CITY OF ALBUQUERQUE

**Re: The Range Cafe
Erosion and Sediment Control Plan
Engineer's Stamp Date 4-12-16 (H13E029)**

Based upon the information provided in your submittal received 4-14-16 the above referenced plan is not approved to be included in the SWPPP or for ESC Permit-Building Permit until the following comments are addressed:

THE RANGE CAFE
RIO GRANDE
EROSION & SEDIMENT CONTROL PLAN

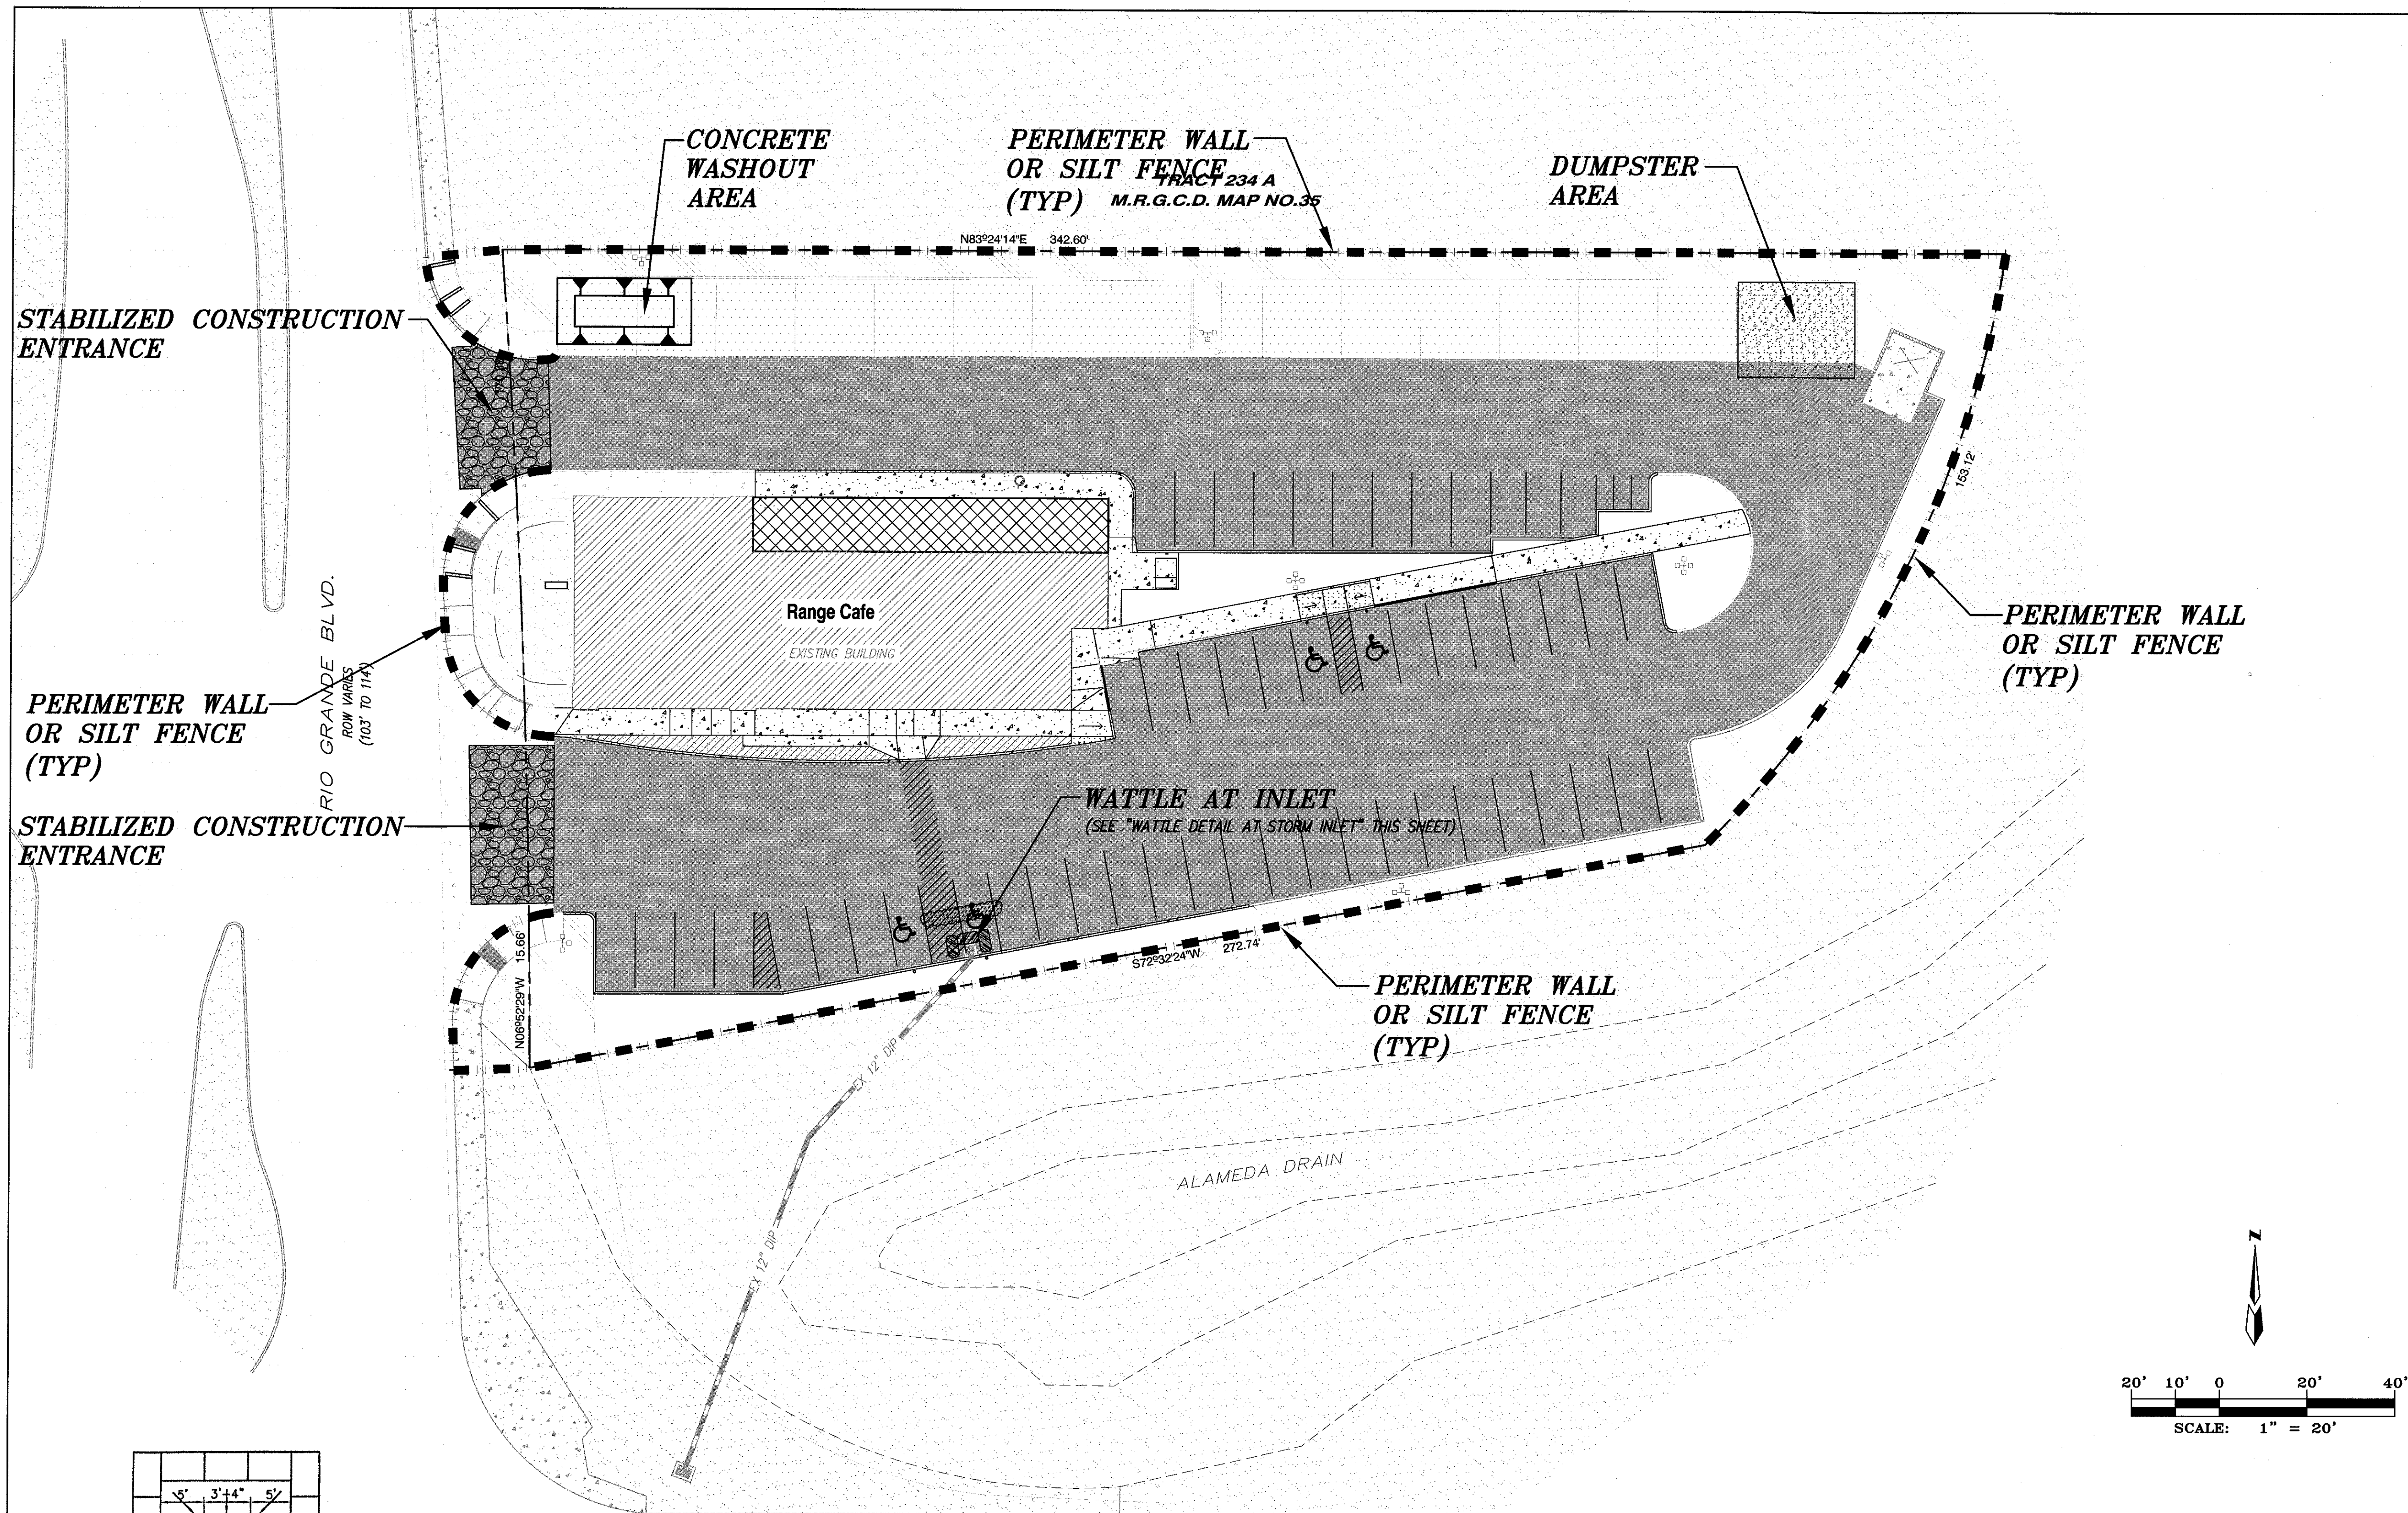
1. It does not appear that the sidewalk and ramps are being replaced on Rio Grande Blvd; therefore, the silt fence should be moved to the back of sidewalk/ramp in these locations.
 - a. In general, silt fence does not seal well on impervious surfaces and a wattle or similar should be proposed by itself or in addition to the silt fence.
2. Include the note: "When doing work in the City ROW (e.g. sidewalk, drive pads, utilities) prevent dirt from getting into the street. If dirt is present in the street, the street should be swept every few days or the same day if rain is imminent.
